FW: SUB19-002 (SEP19-005/Requirement For No Onsite Open Space/Lack of Tree Regulation)

Subject: Re: SUB19-002 (SEP19-005/Requirement For No Onsite Open Space/Lack of Tree Regulation)

This is the application for a long plat on the old Boys and Girls Property the MI school dist. donated to the BGC in 1984 for recreation. I have a post on ND addressing this. https://nextdoor.com/p/mSBjhfbt7hsB?utm_source=share&extras=NDEONTk4OQ%3D%3D&utm_campaign=1703284690389

8/30/23
 JOB NUMBER:
13-118
 SHEET NAME:
SP-01
 SHT **3** OF **10**

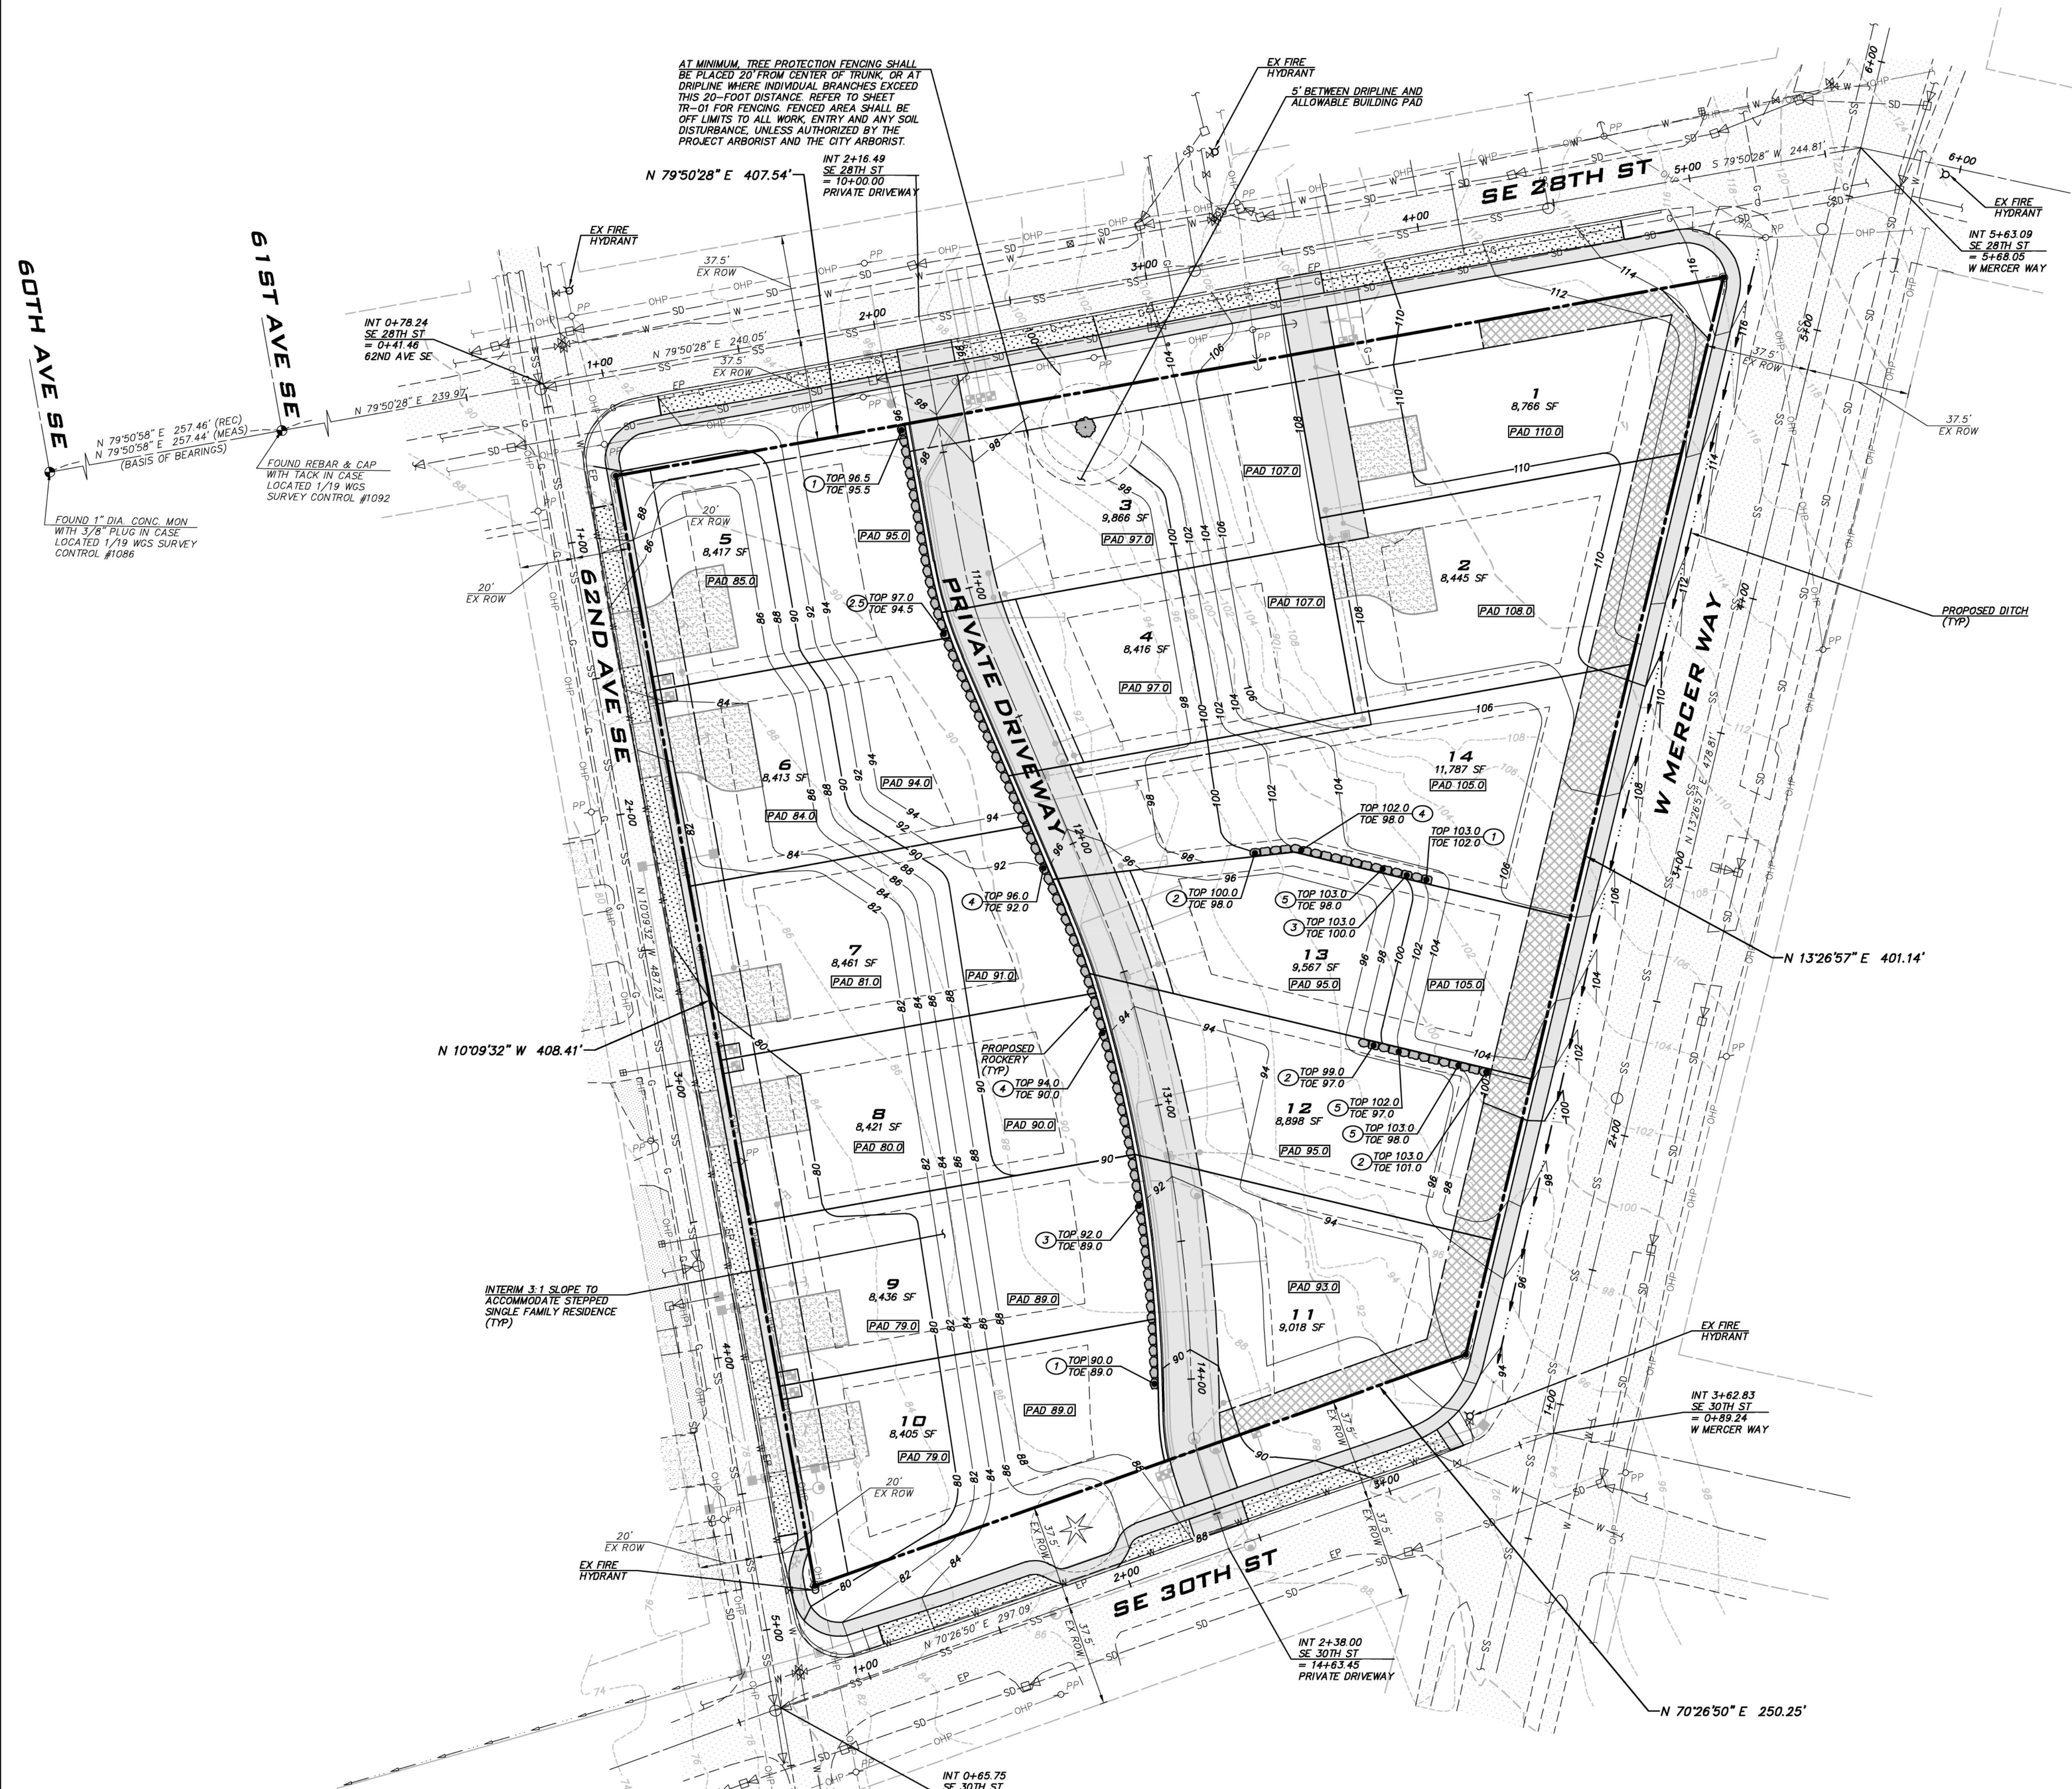
"1. My original objection that the subdivision required an internal access road to reduce direct driveways onto the local streets – very common for subdivisions including The Lakes – has been addressed mostly. But at the expense of providing PUBLIC open space. The city claims that since our local code provision does not set forth a specific "numerical standard" for the amount of open space it can be almost zero, which makes the requirement for open space seem superfluous. It also ignores state law which supersedes local code provisions that do not meet the state minimum requirements. State law requires adequate open space available to the general public. It also ignores precedent with the Coval long plat which the council rejected for failing to provide adequate open space (the city and developer tried to use a ravine and stream bed for open space, and upon remand had to dedicate a lot to open space).

- A. There was no internal access road so all 14 lots had access drives directly onto the street.
- B. There was no meaningful open space available to the public, especially for a parcel that was originally donated to the BGC by the MI School Dist. to remain open and recreational space, and by the purchaser who claimed that was his intent but lied.

The KEY is the internal access road is lot area that is deducted from the total lot area available for lots, AND so is the open space. Under the original plan Evan Maxim demanded there could only be 13 lots because there would be an internal access road, AND meaningful open space for the public. The way the applicant in the most recent design adds an access road and still can achieve 14 lots is by eliminating one of the most important requirements of the MI code and state statute: open space available to the public, on a parcel that was designed to be entirely open space in perpetuity.

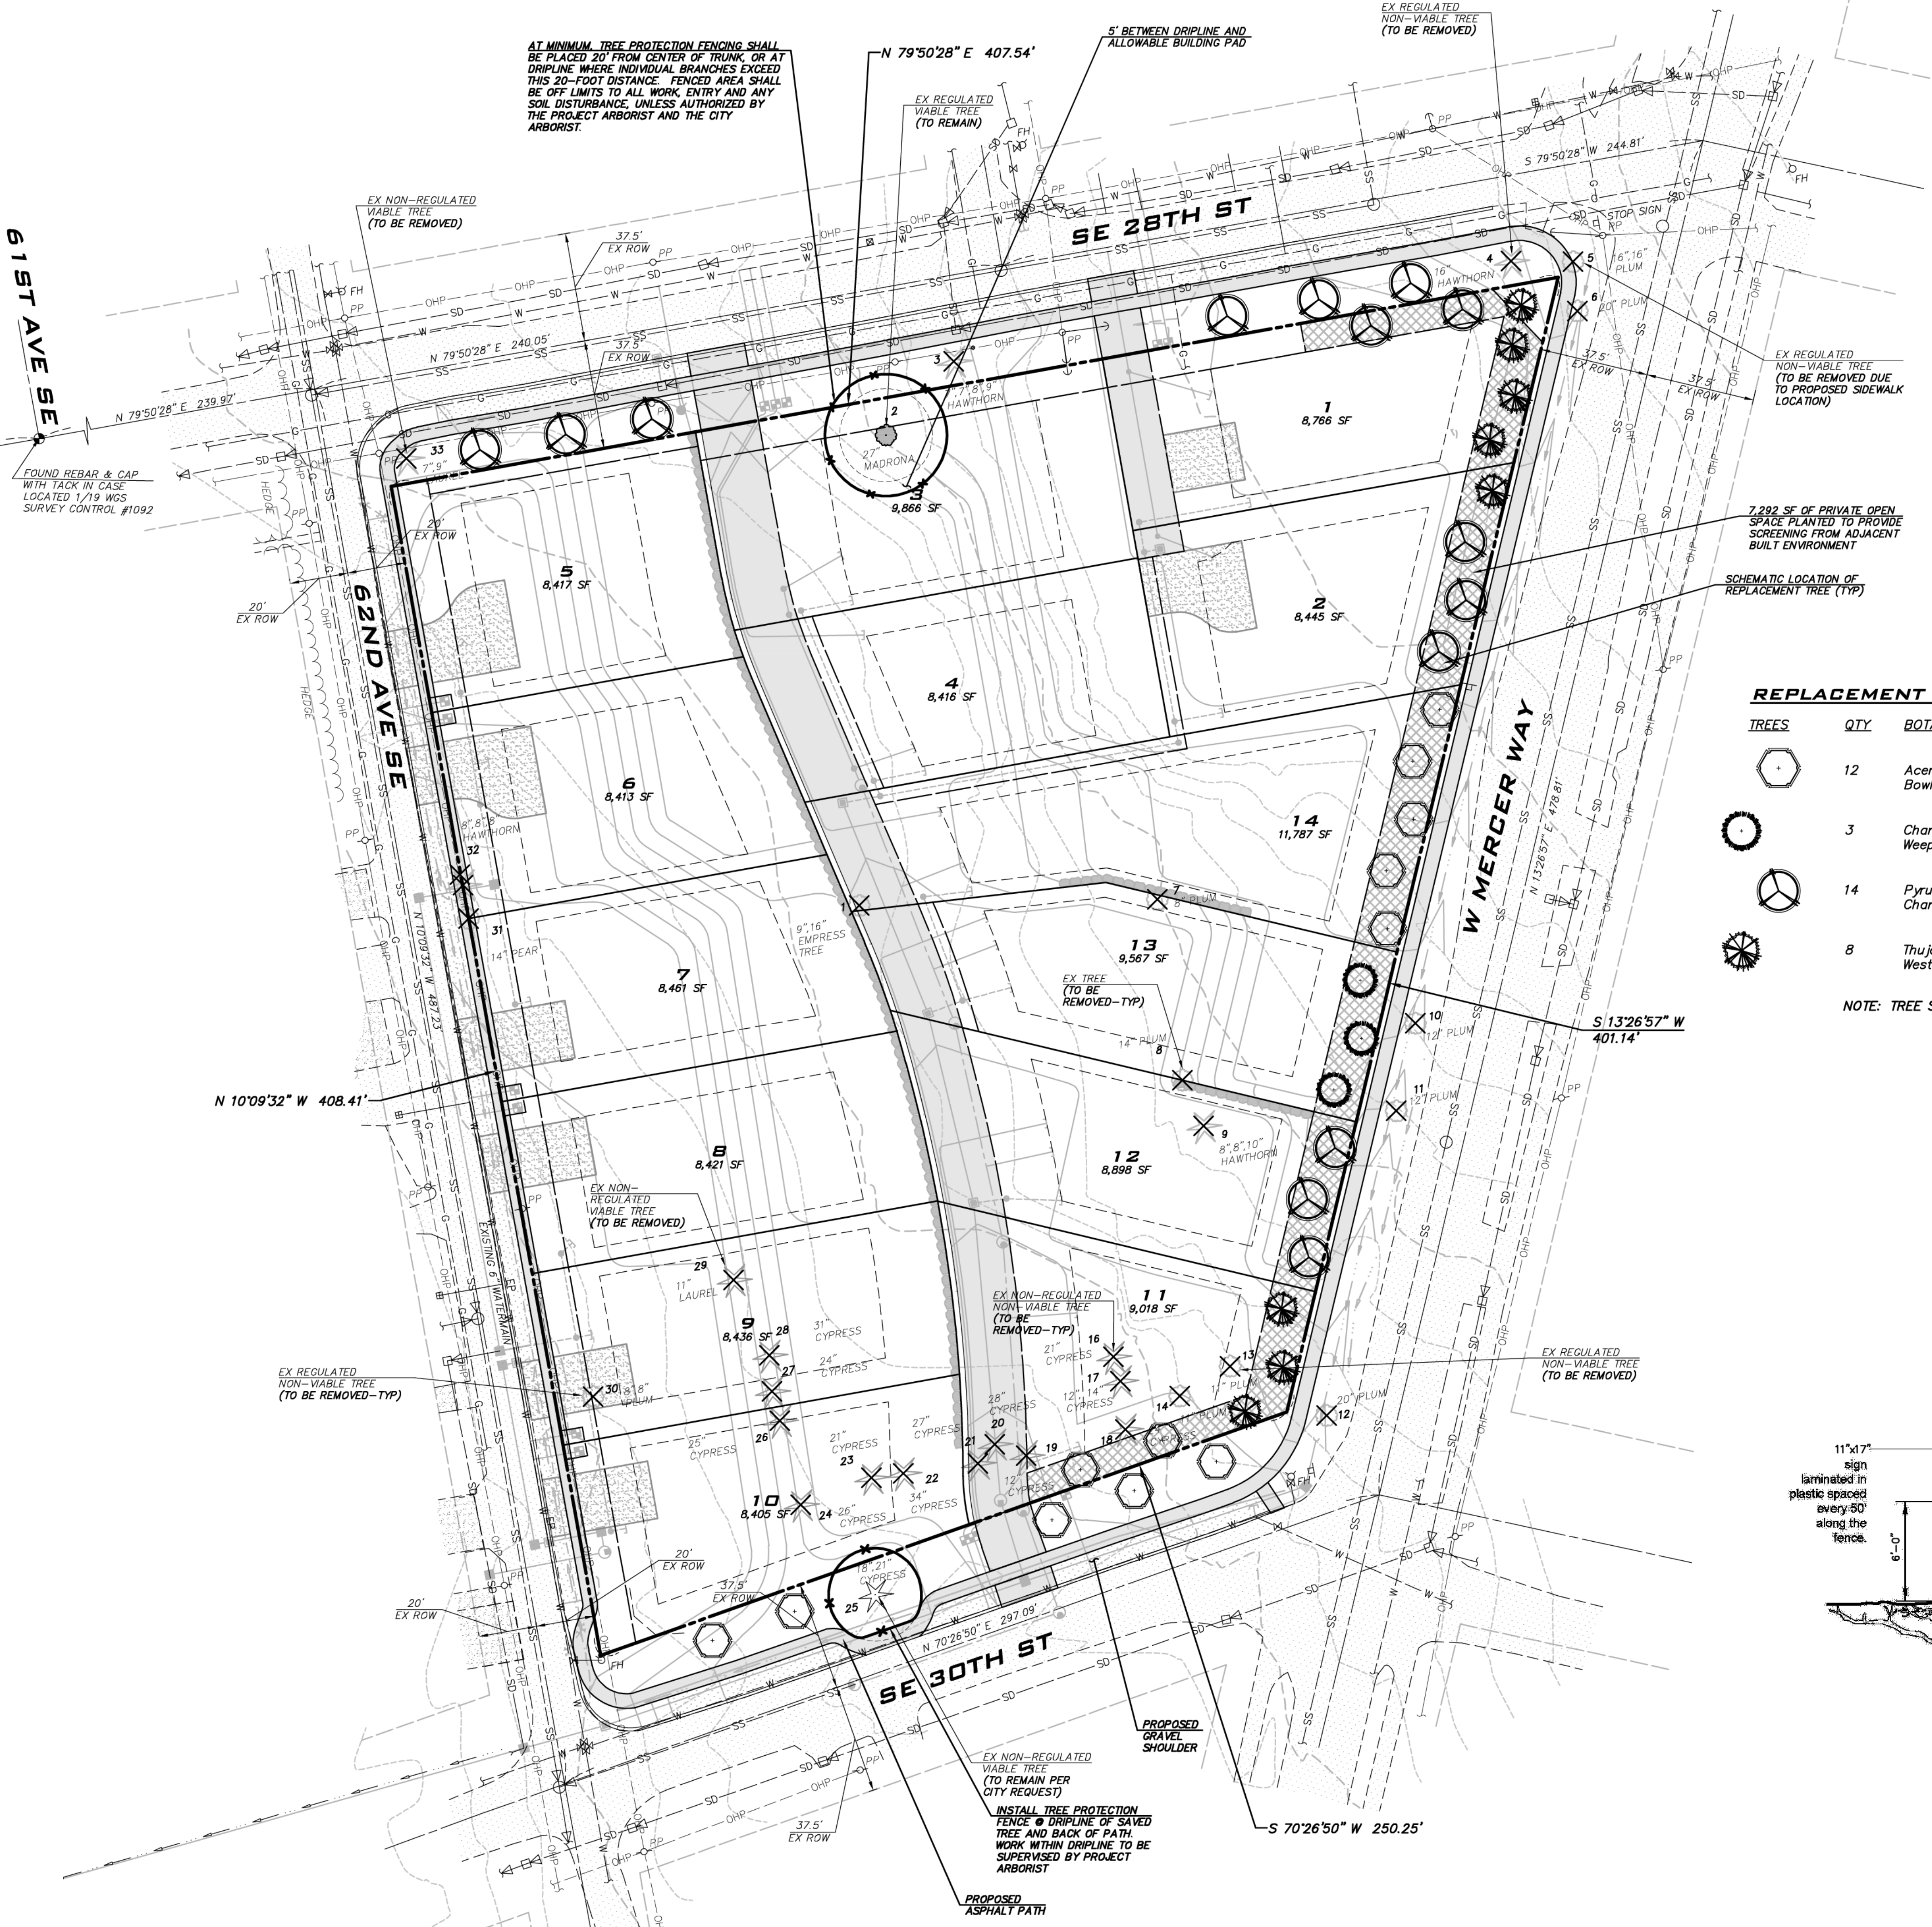
"3. The tree removal is premature. Whether a tree is diseased or needs to be removed for building a house should be reserved until each individual building application is submitted. These are large mature trees that will be replaced with saplings almost one for one, which means there will be a significant loss of tree canopy and privacy. It is ridiculous to allow the owner to remove 36/37 trees in a preliminary application for a subdivision before a single building permit application has been filed.

I also address in my recent reply post Harriman's approval to remove 36/37 trees, 17 the applicant claims are regulated when most are over 20" in diameter, are suddenly diseased, when the applicant's 2019 arborist report never mentions any disease.

PRIVATE OPEN SPACE EASEMENT

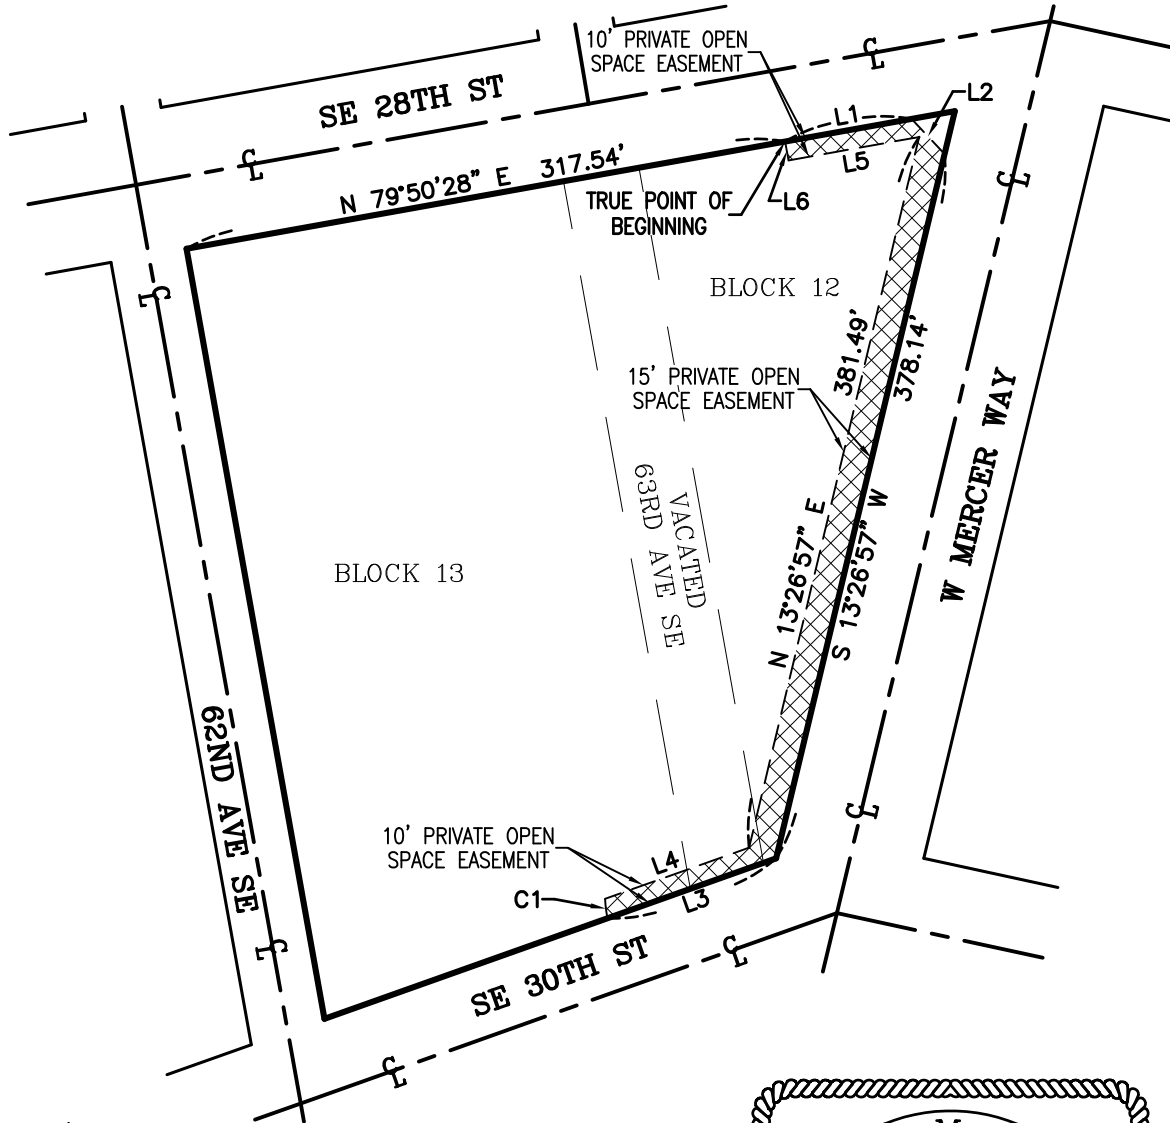
"2. I also think the city planner made a significant mistake. The "open space" is not for the benefit of the subdivision owners – hence the "path" along WMW to the secret park which is really an insult – the open space must be onsite and for the benefit of the entire public, especially the surrounding

neighborhood. This is even more important for this property because of the owner's prior promises, and his own comments in 2008 that this part of the Island has little recreational or open space opportunities for kids. A path from the subdivision to secret park (which is quite small) for the benefit of the subdivision owners misses the entire point of the open space provision.

"Staff Finding: The proposed development makes a provision for open spaces in the form of a private easement for passive open space (Exhibit 5). The MICC does not provide a numerical standard with respect to the level of appropriateness as to the provision of open space".

"Staff Finding: By providing walking access along the West Mercer Way frontage to the Secret Park, the Applicant provides access to existing open space and recreation facilities sufficient to serve the proposed subdivision".

I have never heard of something so absurd. The applicant's "open space" is based on an existing city park accessed by the required setback. Because the planner claims that, *"The MICC does not provide a numerical standard with respect to the level of appropriateness as to the provision of open space"* the planner interprets this to mean zero open space without addressing the requirements under R.C.W. 58.17.020. **Is Jeff Thomas really rewriting state law and the MICC to hold a 14-lot long plat requires no onsite open space, or this is the intent of 19.08? Is Jeff unaware of the Coval long plat?**
